Connah's Quay Low Carbon Power

Applicant's Response to Deadline 3 Submissions

Planning Inspectorate Reference: EN010166

Document Reference: EN010166/APP/9.18

Figure 13-1

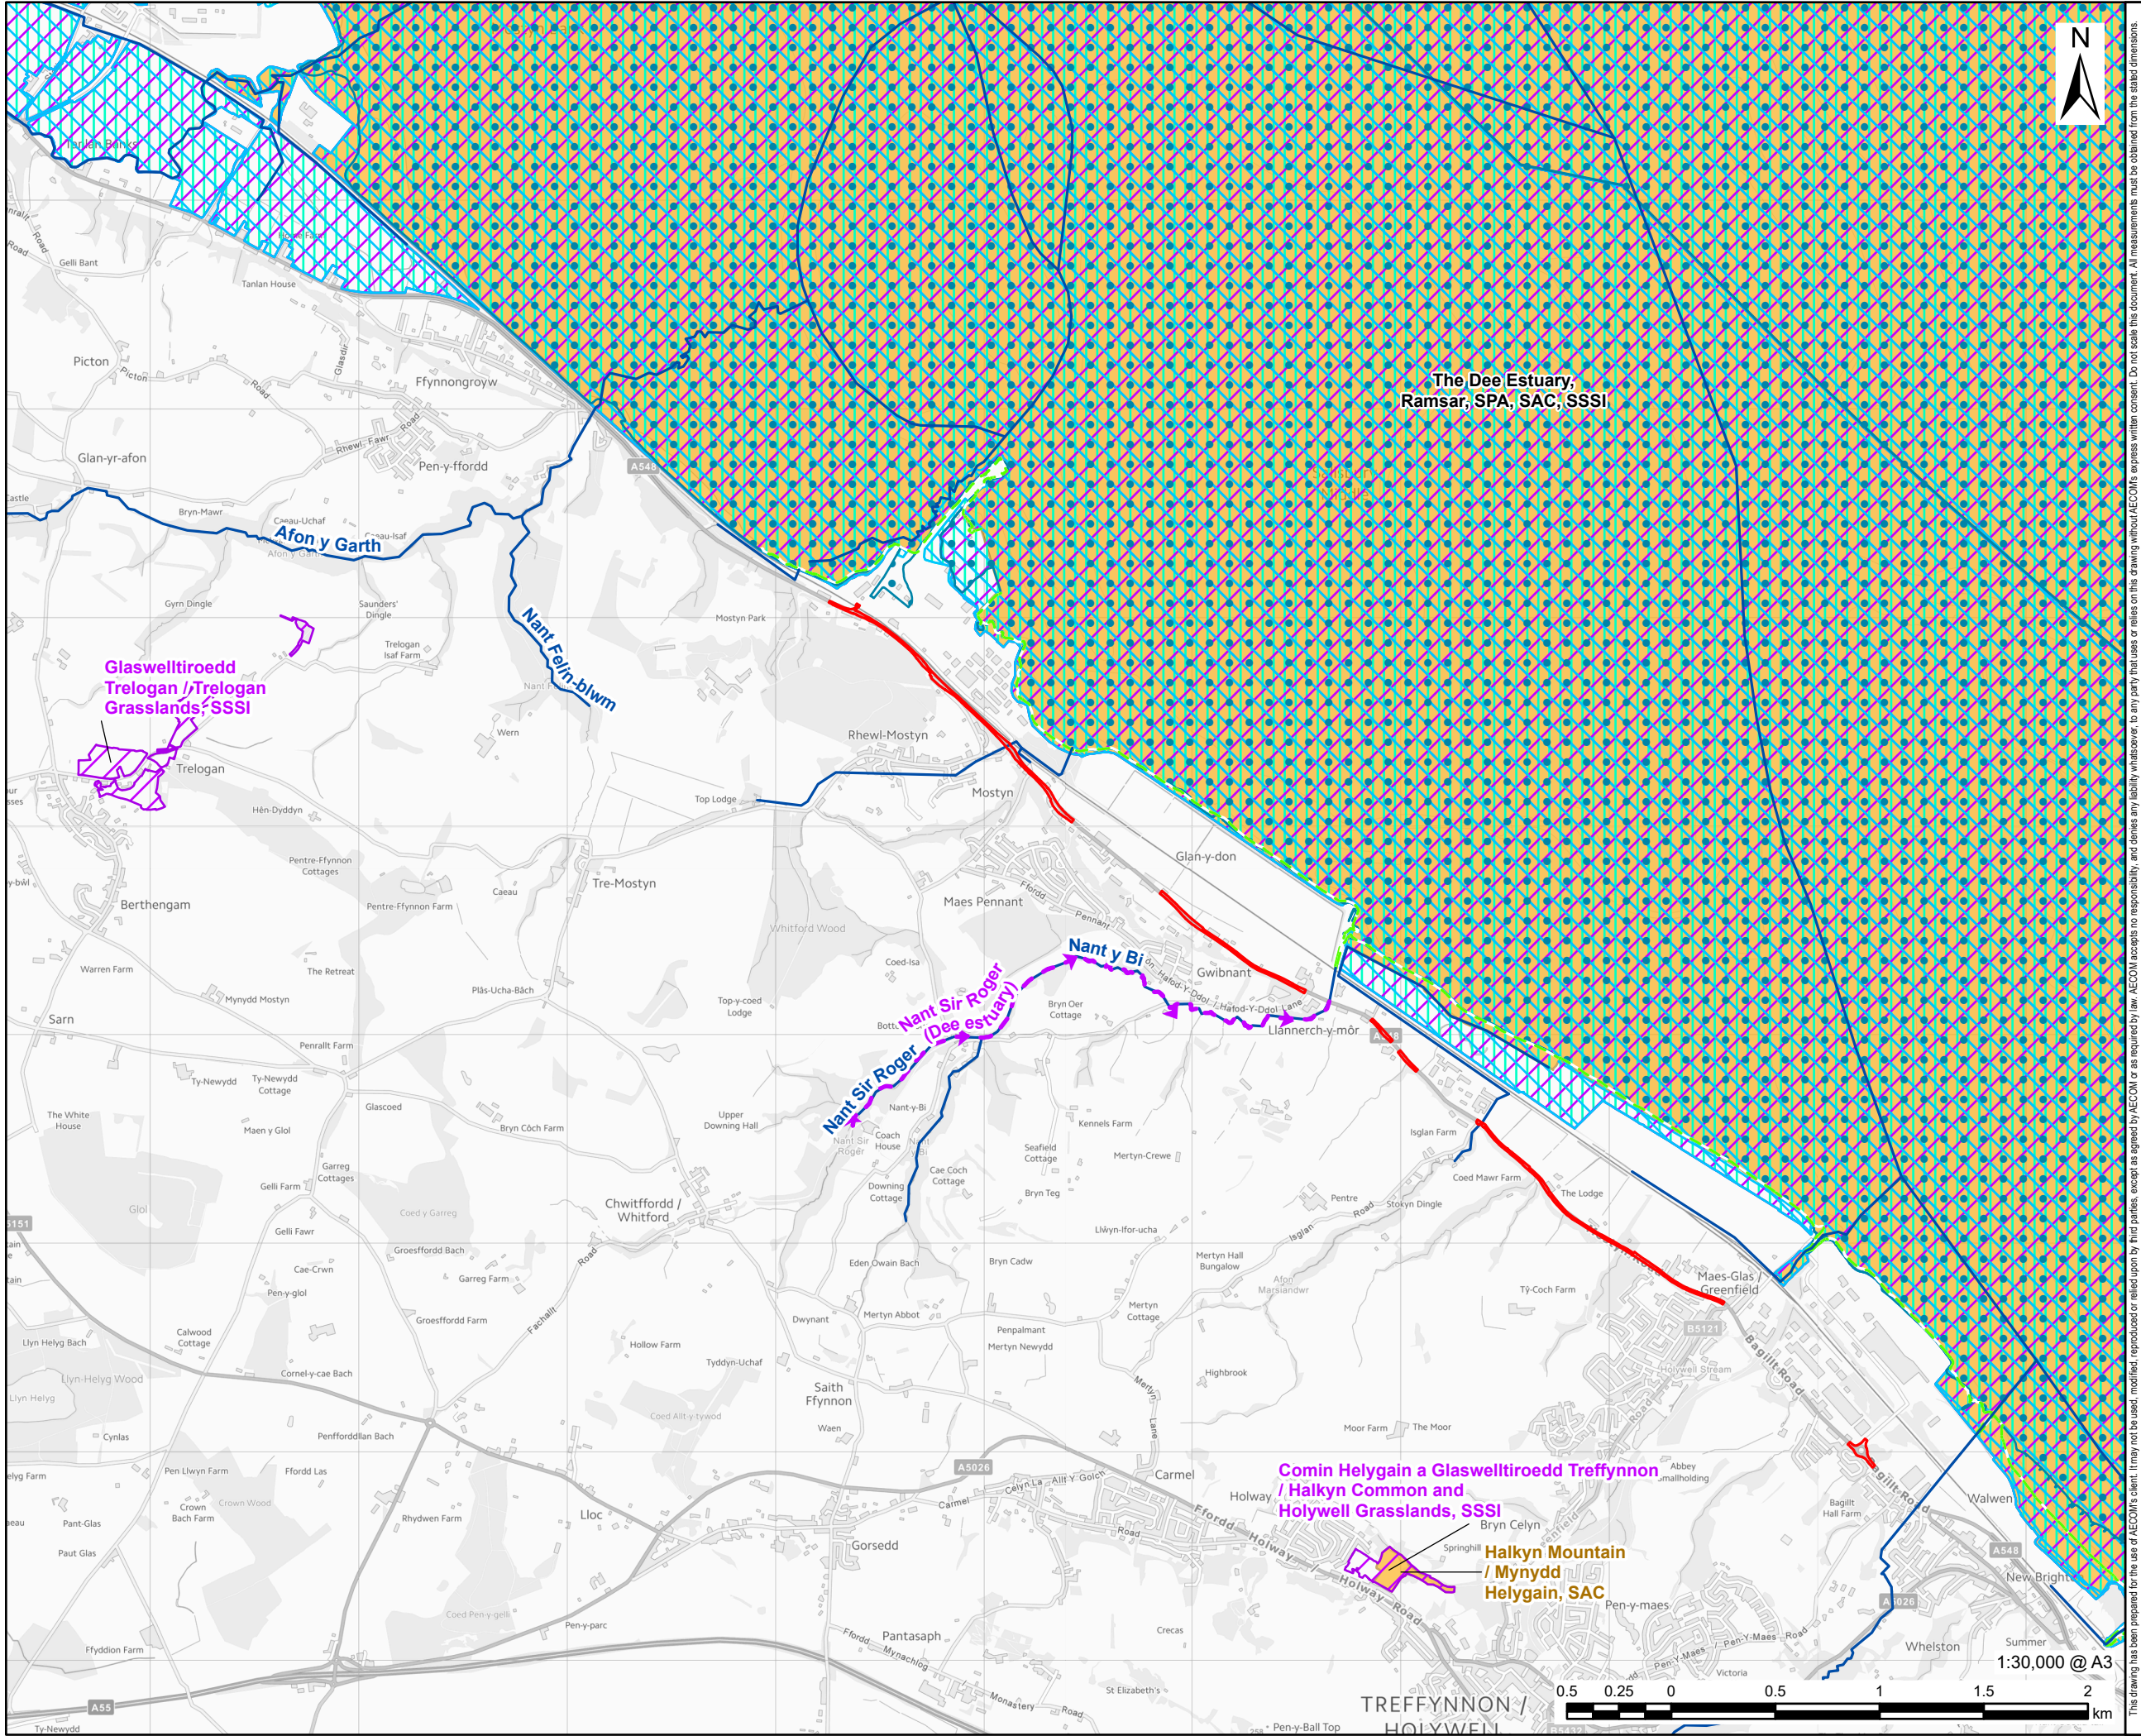
1.36	<p>Question Reference: ExQ1 11.4</p> <p>Examining Authority Question: Flood risk ([APP-051] Ref: Table 13-7 & [APP212] Fig 13C-1) Was joint probability considered in the hydraulic analysis? Where in the tidal modelling has the risk of overtopping of defences from wave action and breach of defences been considered? The appendices state that the MDA is free from flood risk but the Figure 13C 1 appears to contradict this. Why is the site shown in flood zone 3 if the site is actually free from flood risk including future climate change projections? Have the most recent allowances for climate change been included in the flood risk assessment including the uplifts required for flood modelling of critical national infrastructure, such as H++ sea level rise?</p> <p>NRW Response: NRW defers to the Applicant to confirm how they have addressed these matters in their submission. Please also refer to our SoCG with the Applicant (NRW39 – 41). However, regarding</p>	<p>Please refer to the responses provided to ExQ1 Q11.4 in the Applicant's Response to ExQ1 [REP3-059].</p> <p>With regards to wave overtopping, liaison with NRW was undertaken (October 2024) (Appendix 13-F – Hydraulic Modelling Report) [APP-215] which confirmed NRW did not hold any wave data for the site of the wider Dee Estuary. NRW were unaware of historic wave overtopping issues, nor did they hold any historic flood outlines which related to wave overtopping in the site location. They therefore felt it unlikely that wave overtopping is a significant risk at the site.</p>

Source Document	Reference	Source Document Issue / Theme	Applicant's Response
		<p>consideration of a breach in defences for the tidal modelling, this was subject to previous discussions and agreement between the Applicant and NRW. There are no NRW maintained flood risk management defences alongside the Main Development Area and therefore it is considered that the modelling approach (undefended scenario) will provide conservative estimates of flood levels/risk.</p> <p>Regarding the site's susceptibility to flood risk, the Flood Map for Planning at the location of the site is based on broad-scale fluvial and tidal modelling. As part of the submitted Flood Consequences Assessment, the Applicant has taken a copy of NRW's most up-to-date hydraulic model for this location and updated this to provide a more detailed representation of risk to the site, following preapplication engagement between NRW and the Applicant. This is documented in the Hydraulic Modelling Report. Further advice on the details of the modelling should be sought from the Applicant.</p> <p>For the H++ scenario, Section 7 of the Welsh Government's current Climate Change Allowance guidance "Flood Consequences Assessments: Climate change" states that "You should contact the Local Planning Authority to establish whether an assessment of the H++ scenario is required as part of a flood consequences assessment." We therefore direct the ExA to FCC for any further advice regarding this matter.</p>	<p>With regards to the H++ scenario the Flood Consequences Assessments: Climate change guidance (2021)¹ recommends the H++ scenario is more often used for infrastructure with a longer design life beyond the end of the century and / or is particularly sensitive to flooding. The Proposed Development has a design life of 30 years, and it was shown in Figure 13F-20: Tidal Maximum Extents (70th Percentile Events) in Appendix 13-F: Hydraulic Modelling Report [APP-215] to be no flooding within the operational footprint during the design flood event.</p> <p>Within the Statement of Common Ground with Flintshire County Council [APP-280] the assessment methodology for the Flood Consequence Assessment was agreed between the parties to be appropriate / acceptable.</p> <p>Within Table 12 of the Applicant's Response to Local Impact Report [REP3-058] it is noted that FCC would defer to comments from NRW, as the statutory body for coastal and fluvial flood risk, on matters relating to flooding.</p>
